# MONA OFFSHORE WIND PROJECT

## Response to Hearing Action Points

Application Reference: EN010137

Document Reference: S\_D1\_5

Drawing Title:
MONA OFFSHORE WIND PROJECT AND AWEL Y MŌR
OFFSHORE WIND FARM WORKS AREAS OVERLAYS

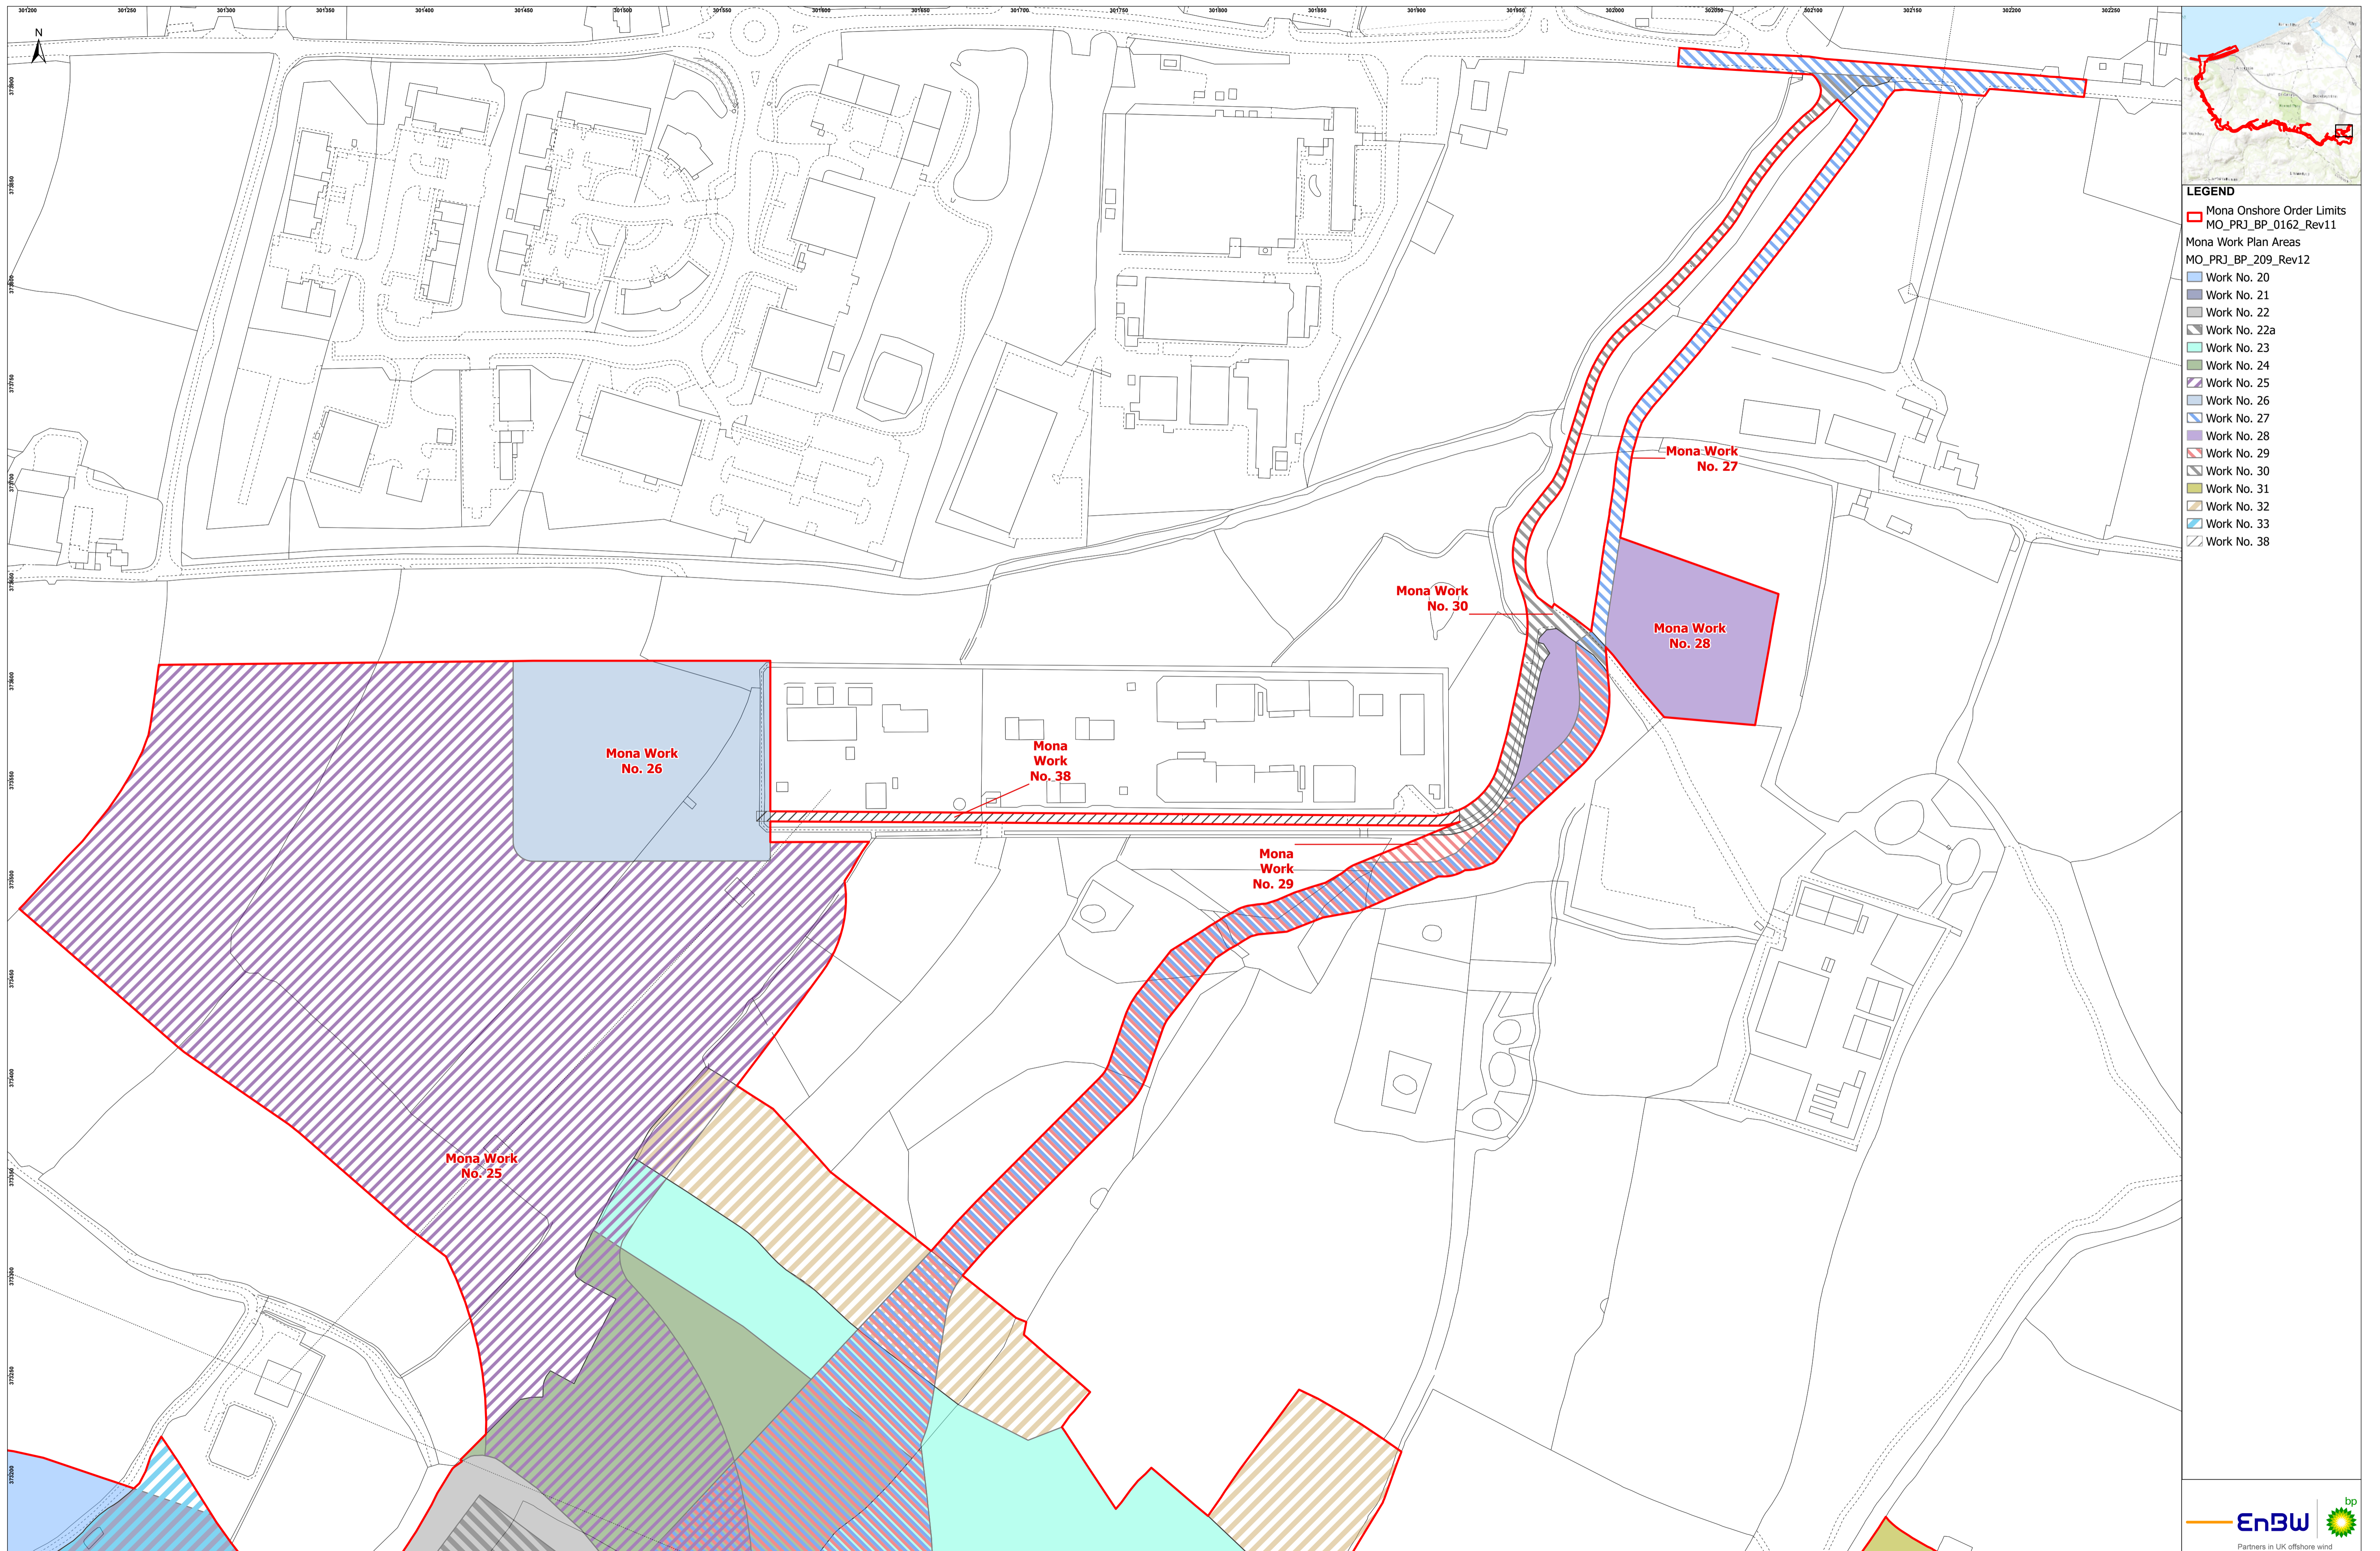
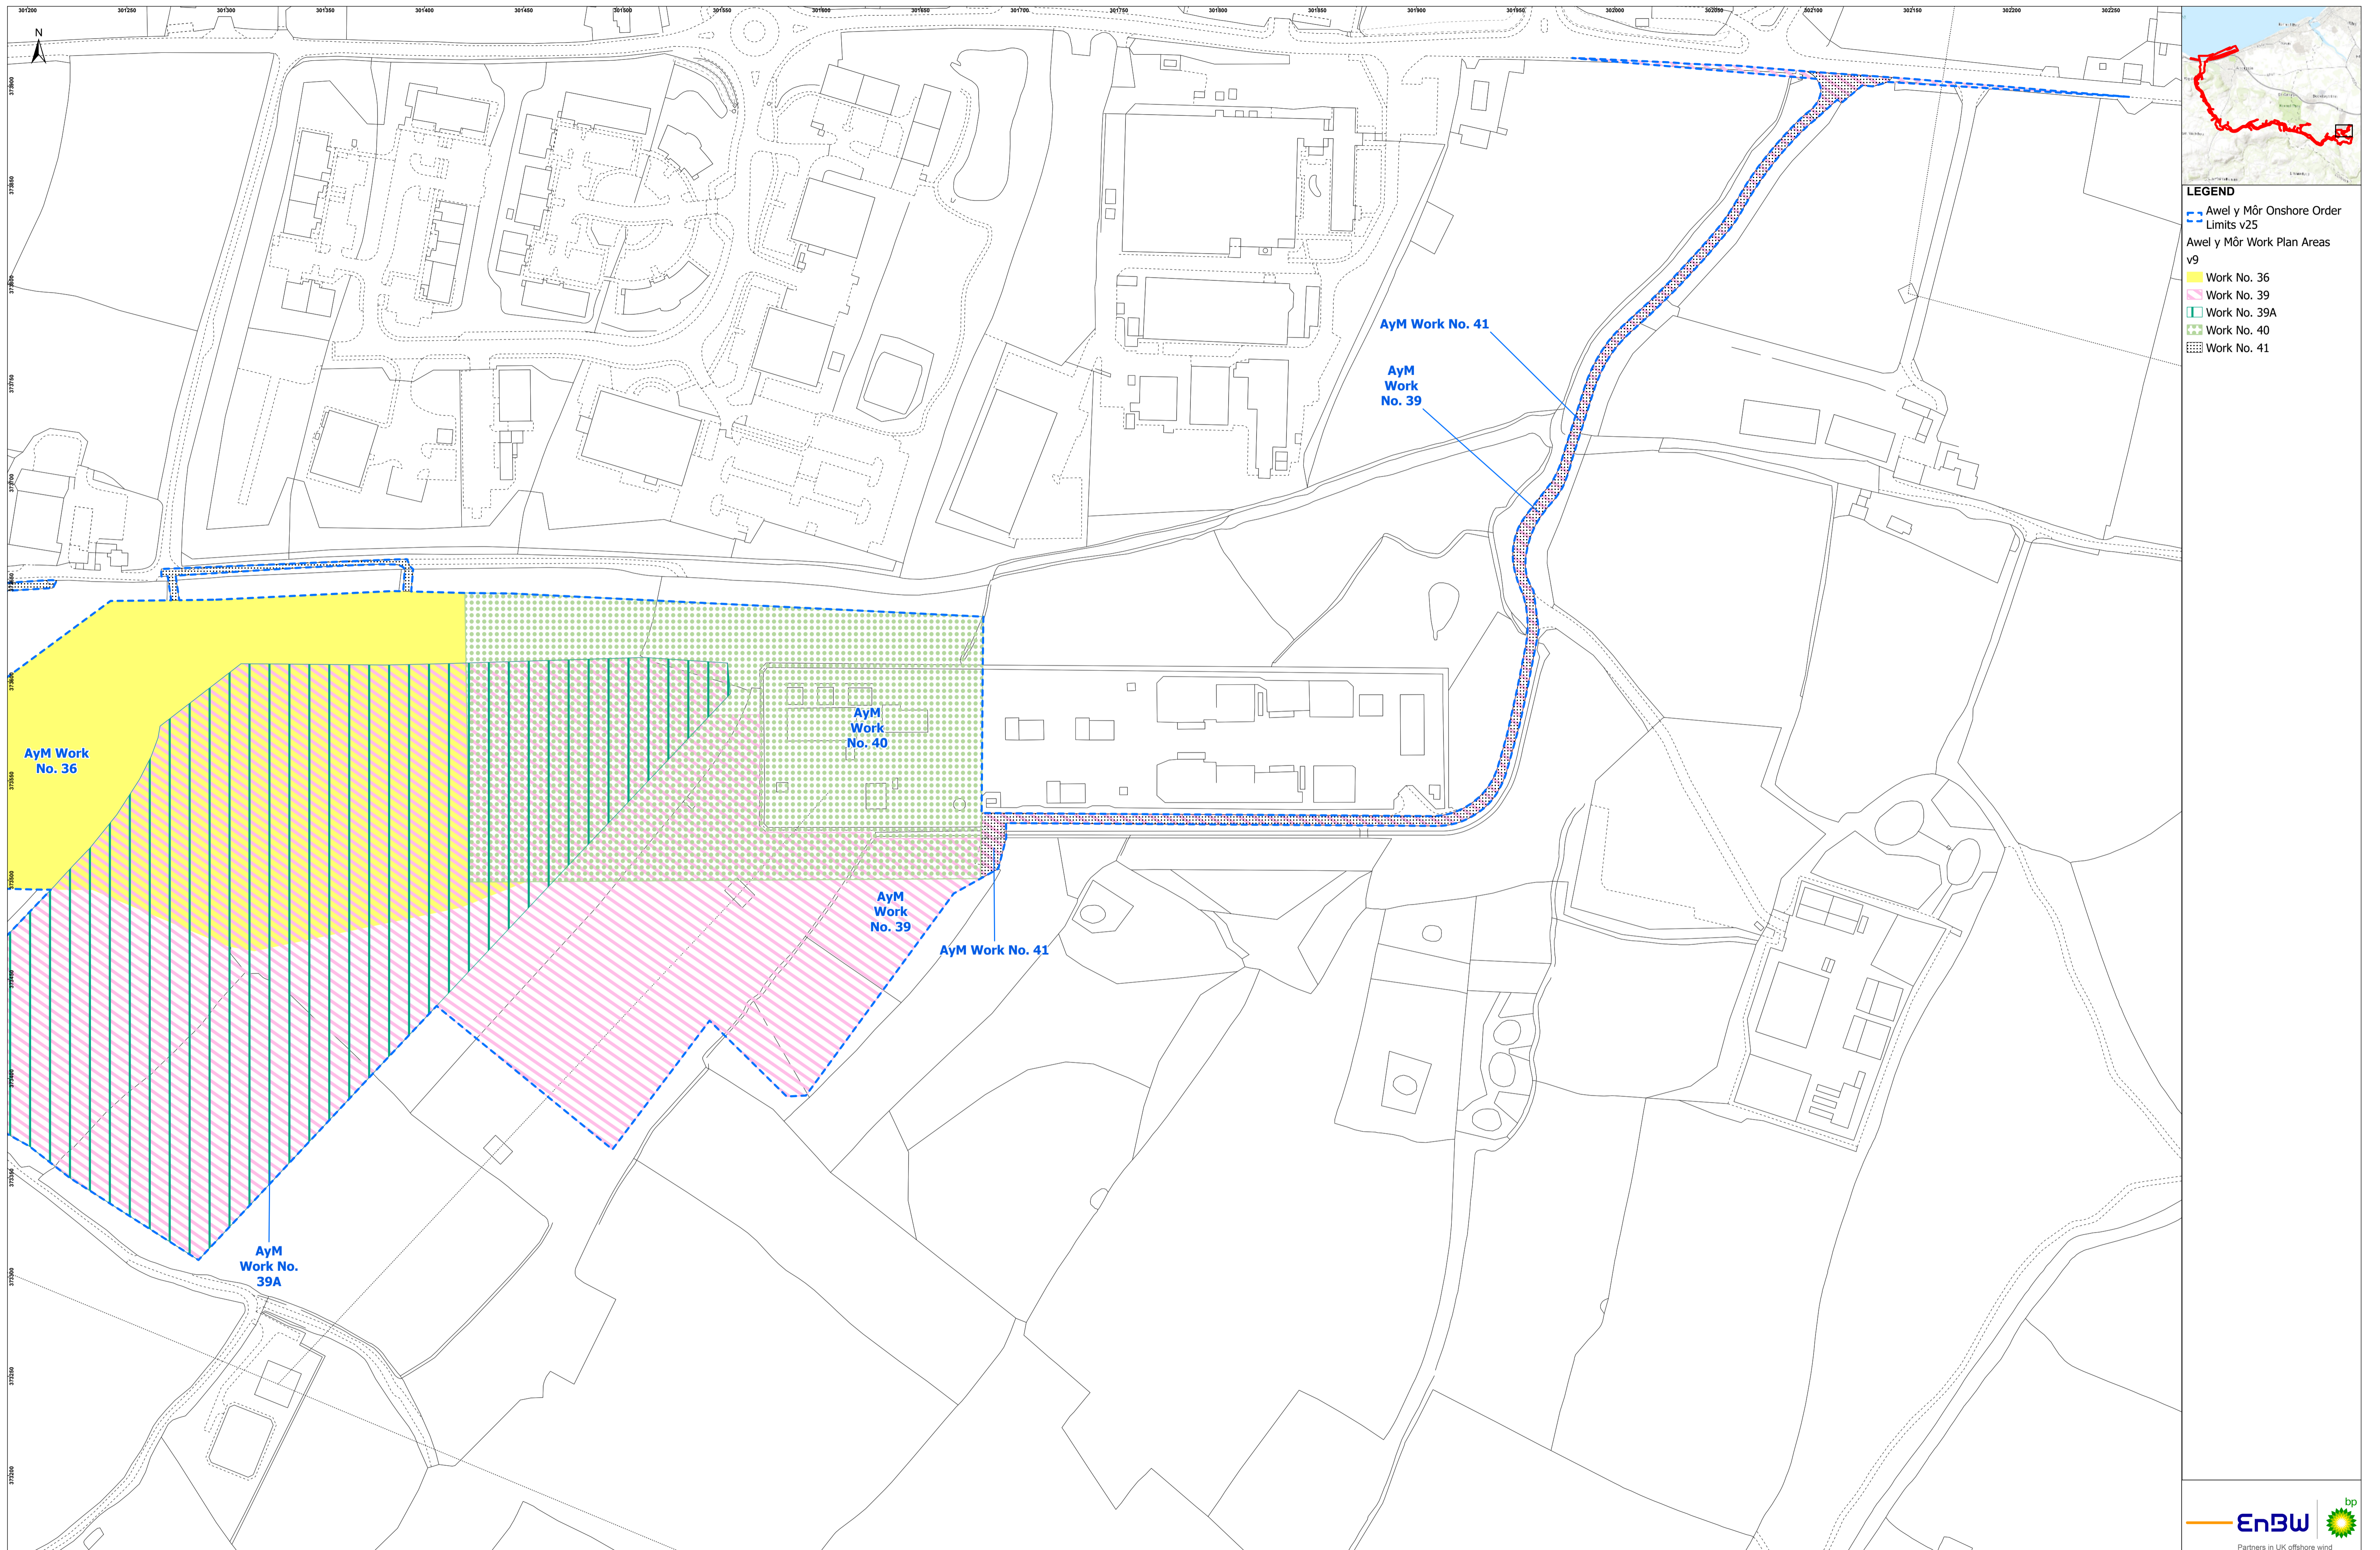
Ref.	Directed to	Action	Applicant's response
			<p>The last row of the table entitled 'Total vehicle movement requirements (Substation) – Mona Offshore Wind Farm' contained within Appendix A of Volume 7, Annex 8.5: Construction Vehicle Trip Generation Assumptions (APP-175) also provides a profile of the total two-way movements per day throughout the proposed period of construction of the onshore substation – including move HGV movements and light vehicle movements. This also shows that total movements peak during months 19 to 22 of the onshore substation construction programme.</p>
HAP_ISH2_15	Applicant	Supply overlay plan showing Mona and Awel y Mor Order Limits in area of approved and proposed sub-stations. Update this plan with National Grid Substation planning application	Please see Appendix to Response to Hearing Action Point: Mona Offshore Wind Project and Awel y Môr Offshore Wind Farm Works Plans Overlays S_D1_5.7 submitted at Deadline 1.
